FW: AL/20/26/PL - Land at West Barn, Norton

Further to our conversation yesterday, I have been liaising with our drainage consultant and we thought it would be helpful to specifically set out the issues which require further justification and explanation. As such our drainage consultant sets these out below;

TYPICAL DETAILS OF SOAKAWAY USING
MODULAR UNITS

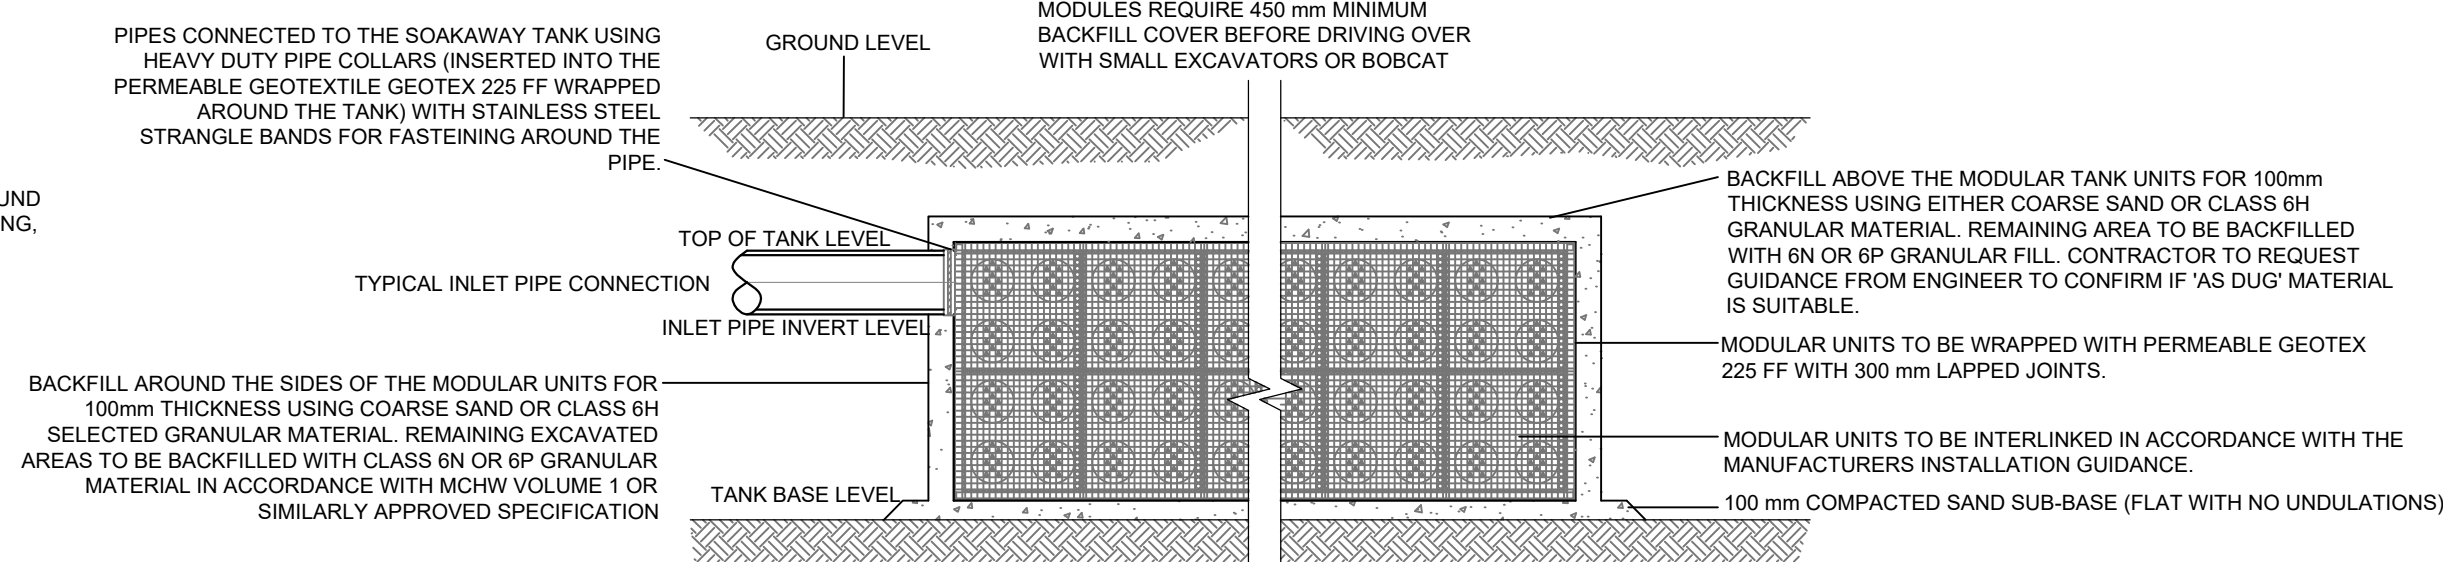
Thirdly, The drainage officer mentions that a coefficient at the base of the soakaway is not allowed. We cannot fathom why this is the case. Immediately upstream of the soakaway feature, we have a filter manhole that ensures sediment and oils are separated and will not enter the soakaway. Upstream of the filter manhole we have a catchpit manhole with a 500mm sump that captures any silt running off the hardstanding areas prior to connecting into the soakaway. The testing performed was at the designed base level and therefore coefficient at base should be applied as represented in our hydraulic calculations.

Trial Pit & Test No.	TPSK1 Test 1
Site Name	Westergate, Chichester
Project No.	22102

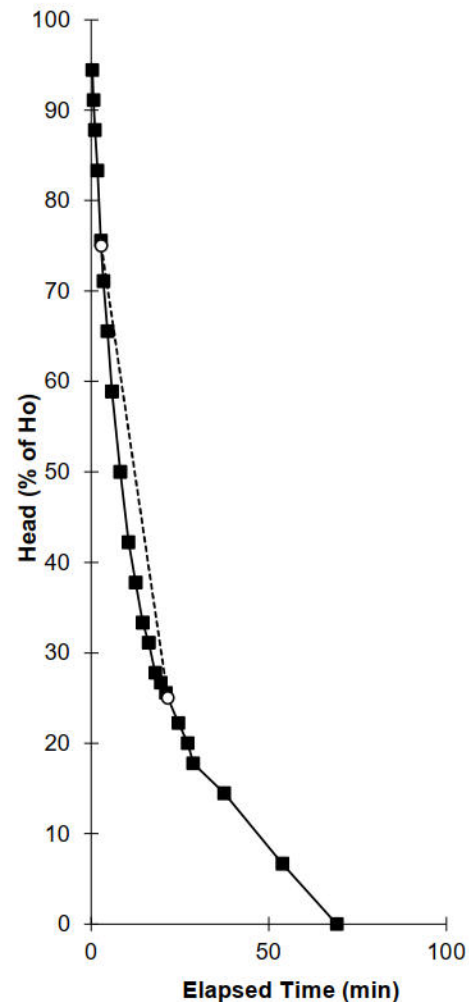
Secondly, Soils Ltd carried out the soakage testing according to BRE 365. It is therefore unclear why the drainage officer assumes the testing does not meet the design standards? We believe it does and therefore a FoS of 5 is applied.
